CITY OF ALBUQUERQUE

March 11, 2025

RE: 2500 Phoenix Ave. NE
Menaul & Vasser
Grading & Drainage Plan
Engineer's Stamp Date: 01/03/2025
Hydrology File: H16D156
ABQ-PLAN File: HYDR-2025-00060

MENAU AND VASSAR
 2500 PHOENIX AVE NE, ALBUQUERQUE,
 NM, 87107
GRADING AND DRAINAGE PLAN

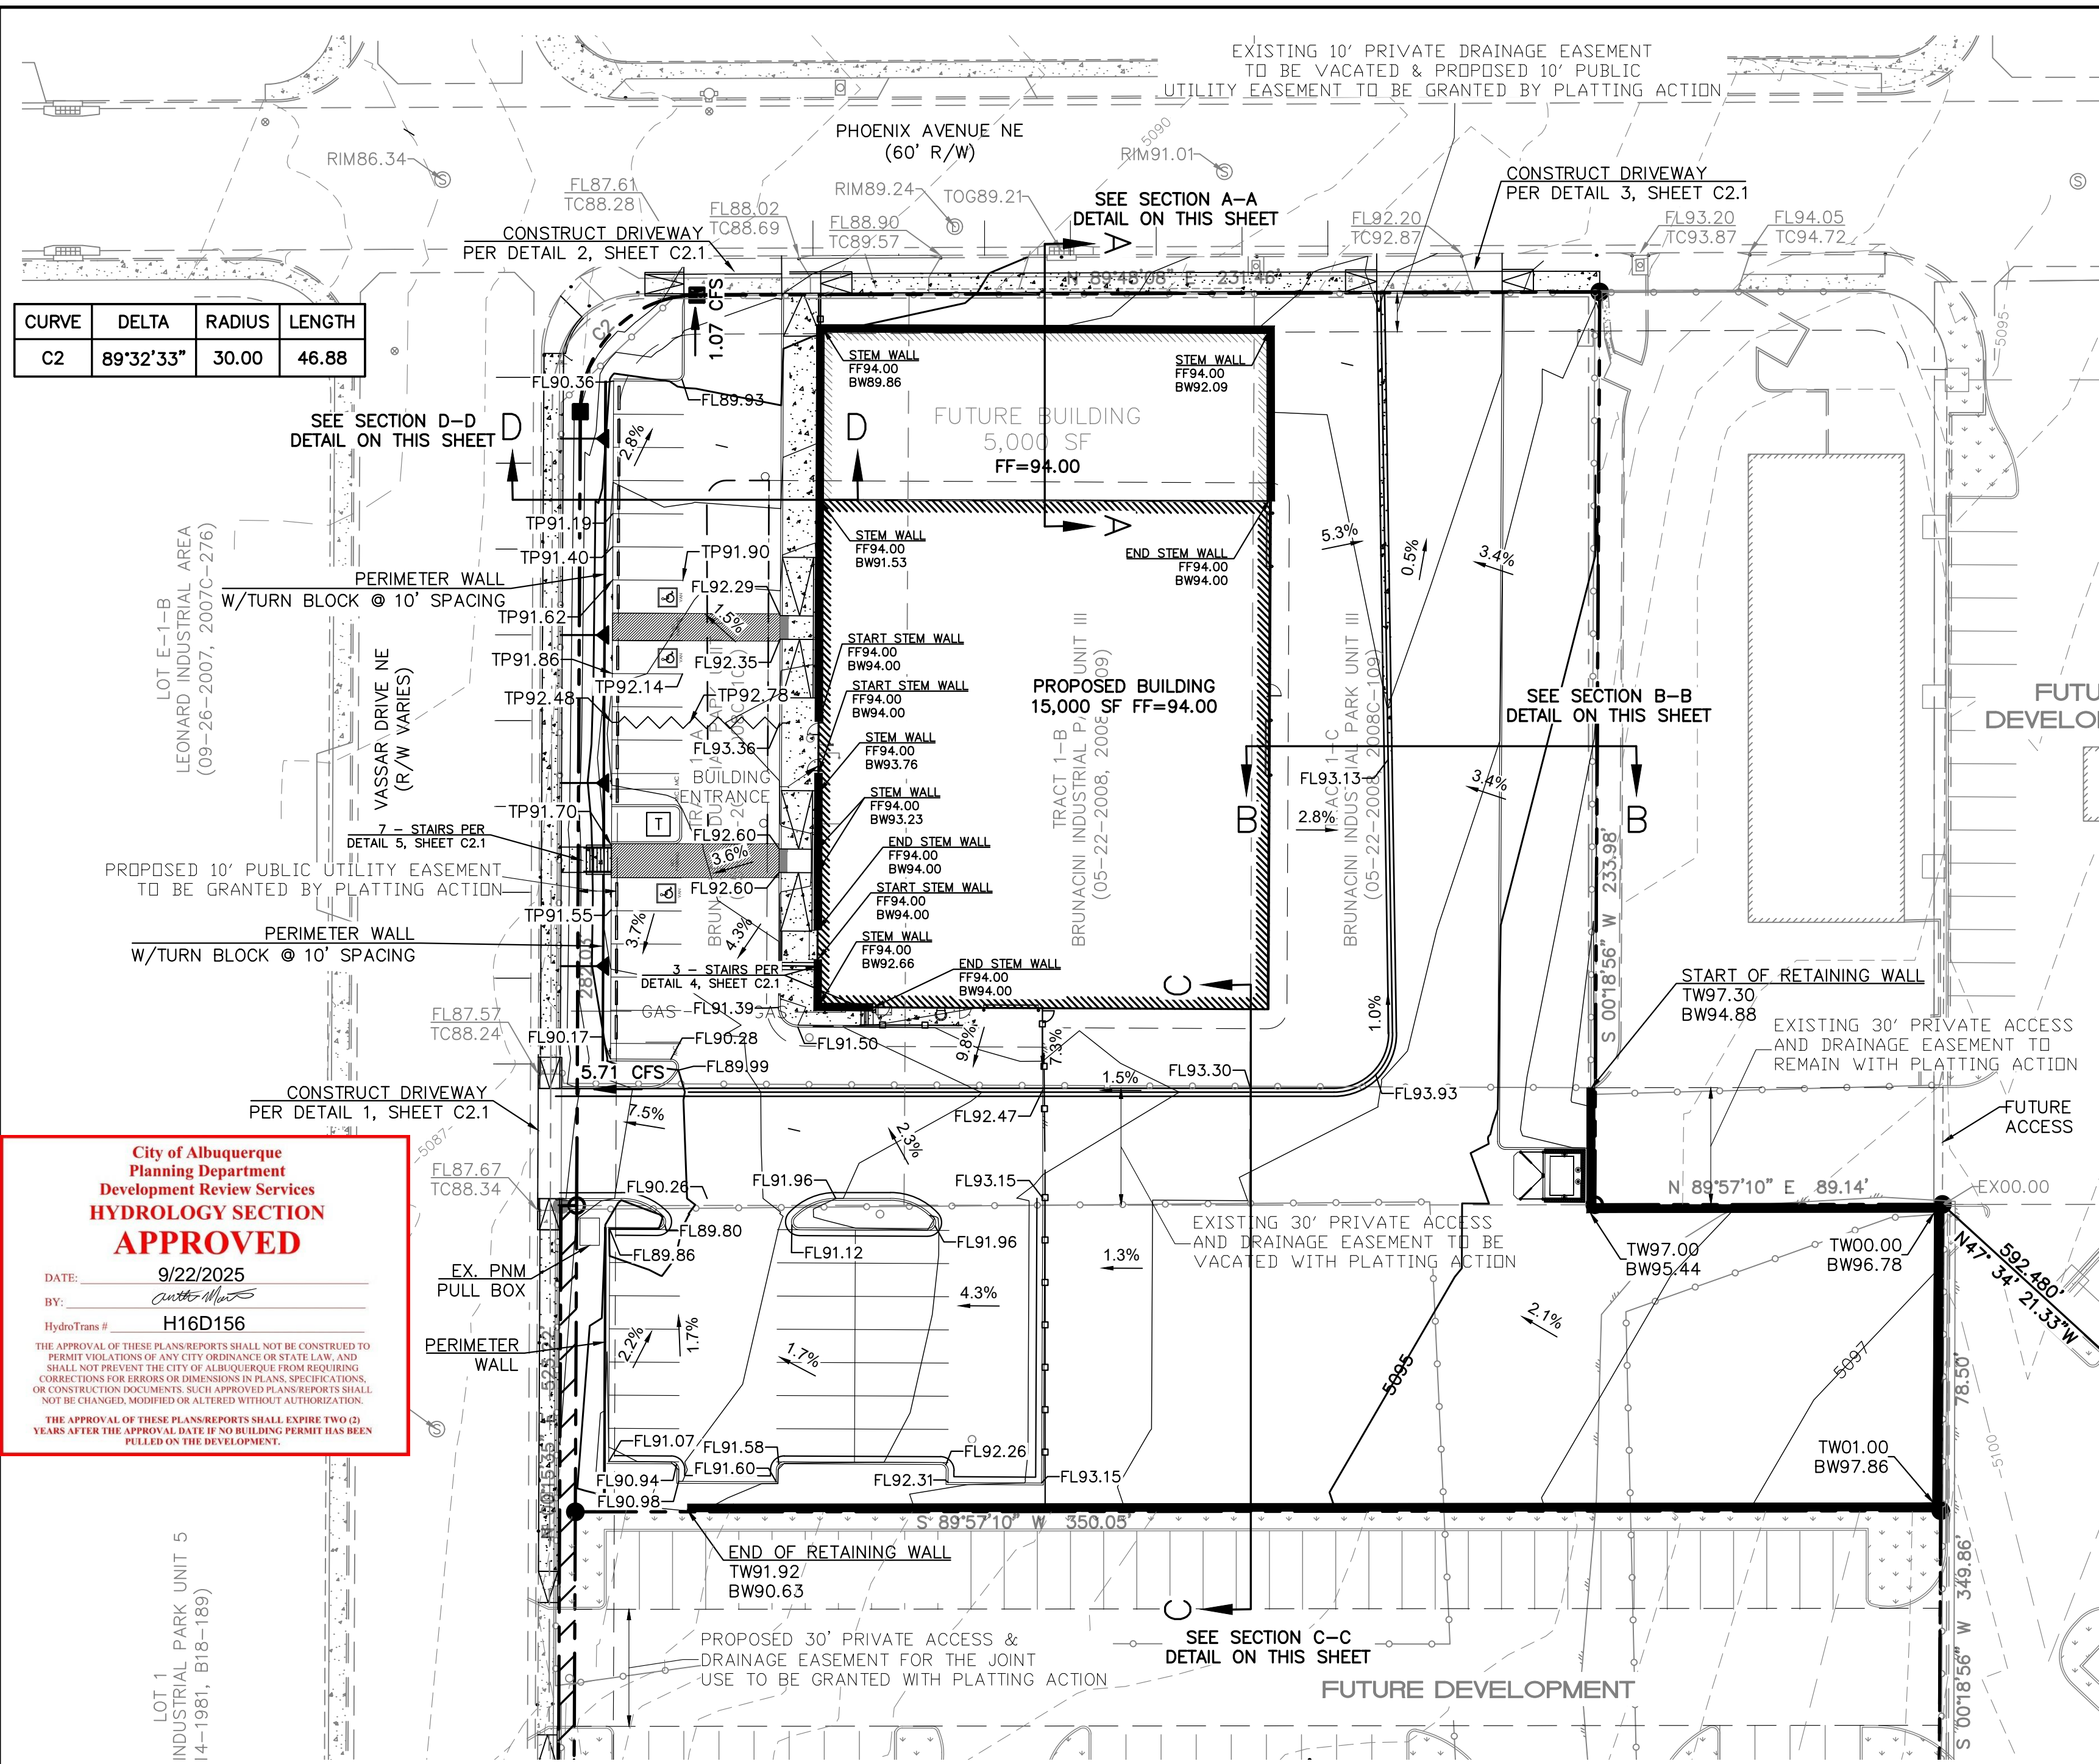
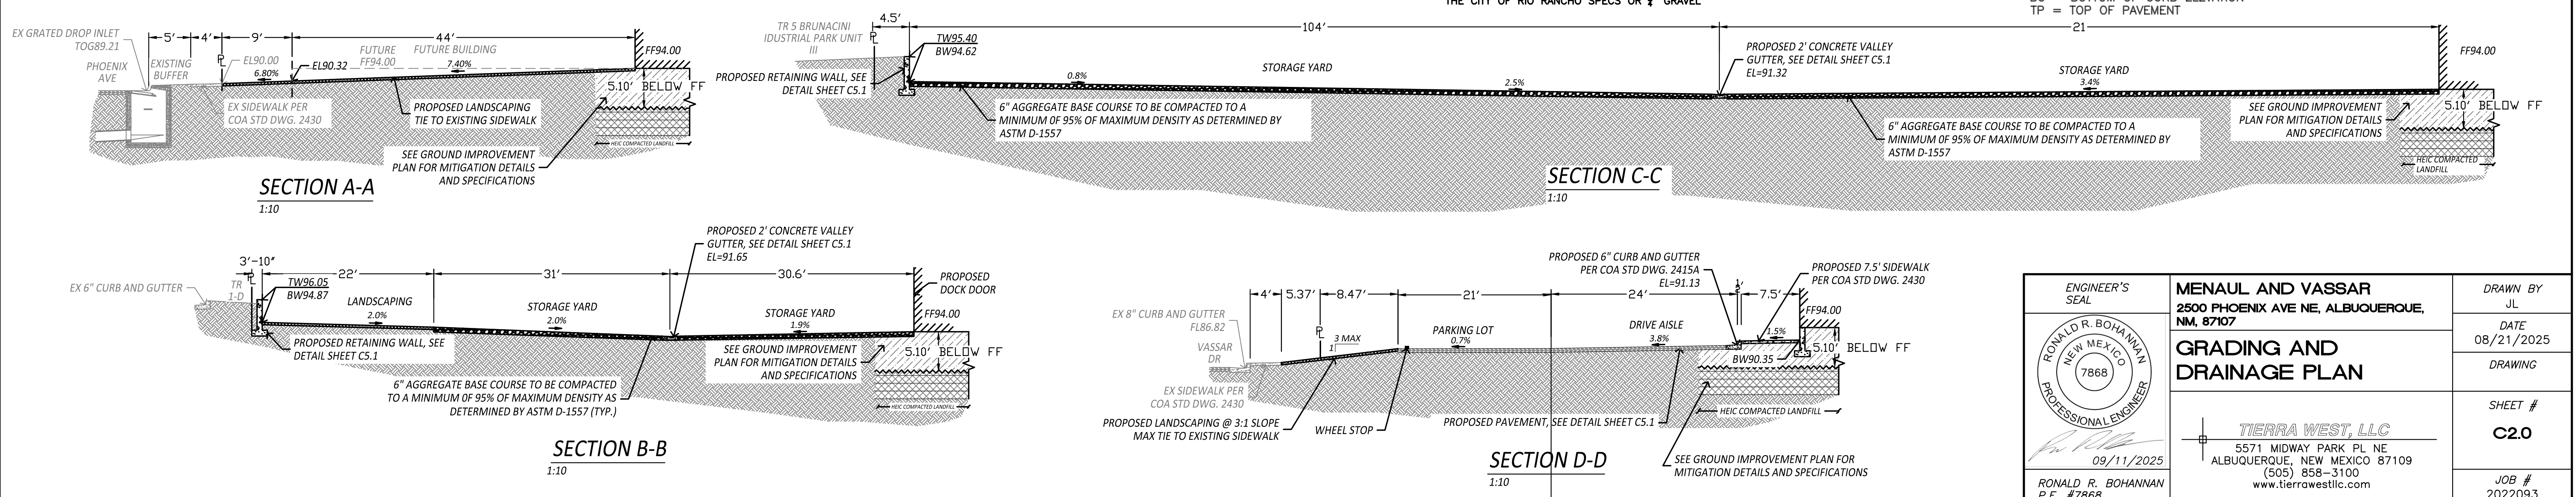
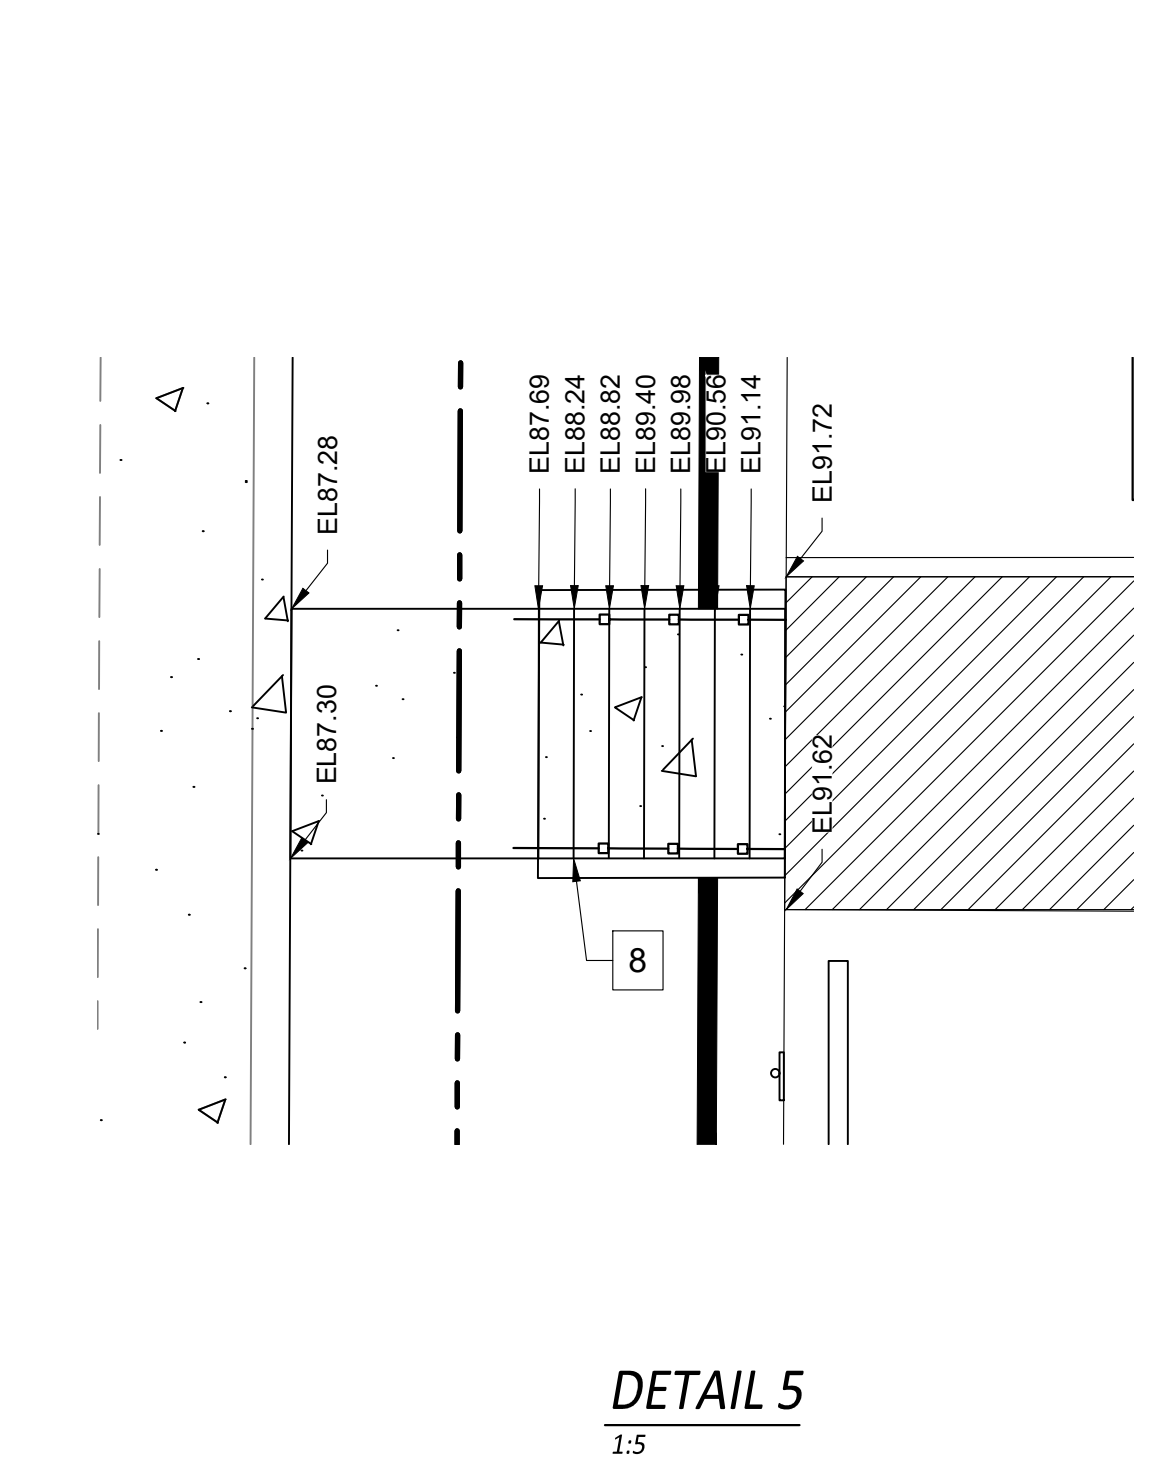
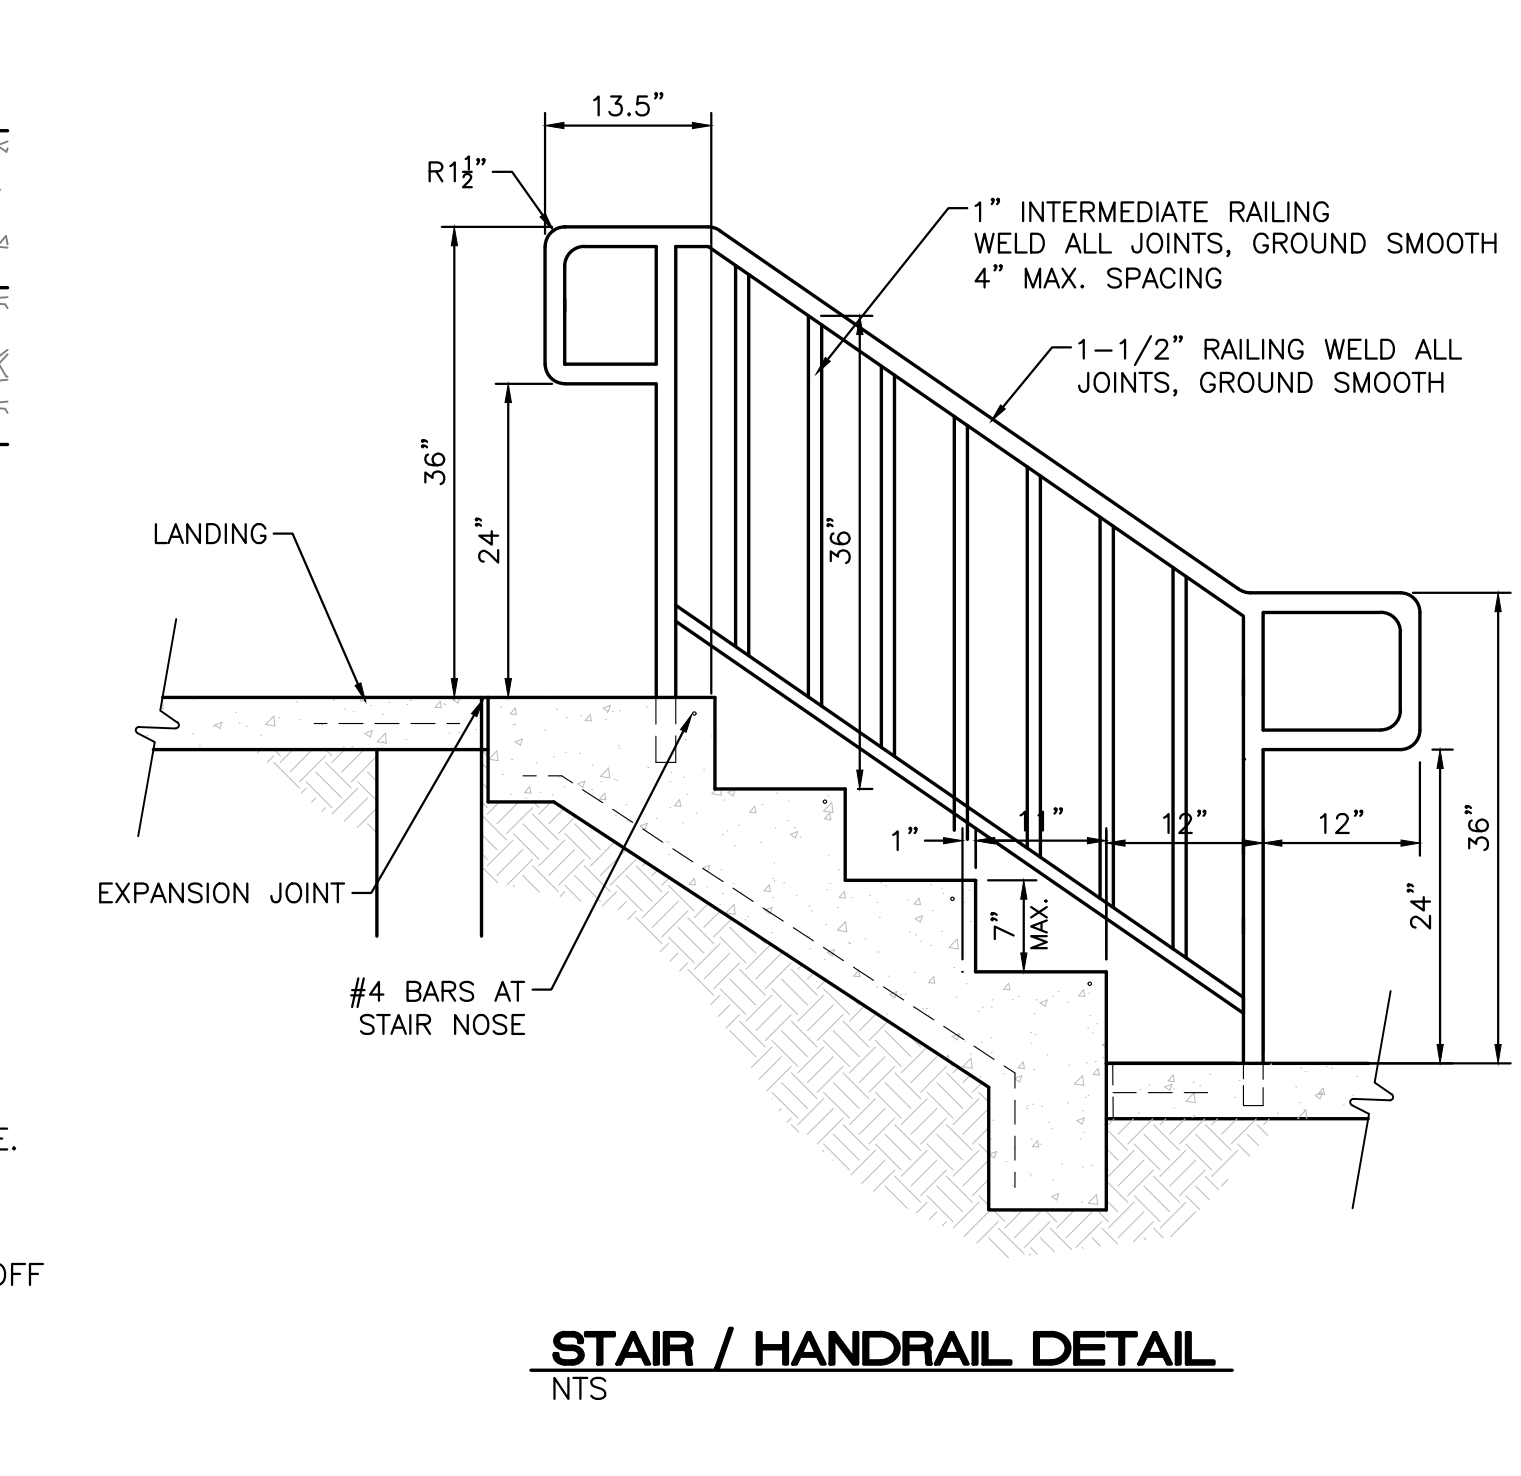
5. Sheet C2.0: Review and revise all slope percentages and directional arrows to ensure correctness. There appears to be incorrect slopes and arrows near Section C-C and Section B-B where retaining walls are proposed.

6. Sheet C2.0: Review and revise all callouts for spelling, in particular, for the 6" aggregate base course description.
7. Sheet C2.0: Review and revise all Legend and Plan information and depictions regarding Base Course and Gravel.

8. Sheet C2.0: From field observations, the existing 30' Private Access and Drainage Easement appears to be providing access to the property/parcel/business to the east of this project which would be adversely affected by the proposed retaining wall, both for vehicular access and stormwater conveyance.
9. Sheet C2.1, The Existing Basin Map: From field observations and topographic mapping review, said Existing Basin Map should be reviewed and revised to reflect actual existing conditions.
10. Prepare and provide a response to each of the above items in a subsequent resubmittal for further review is required.
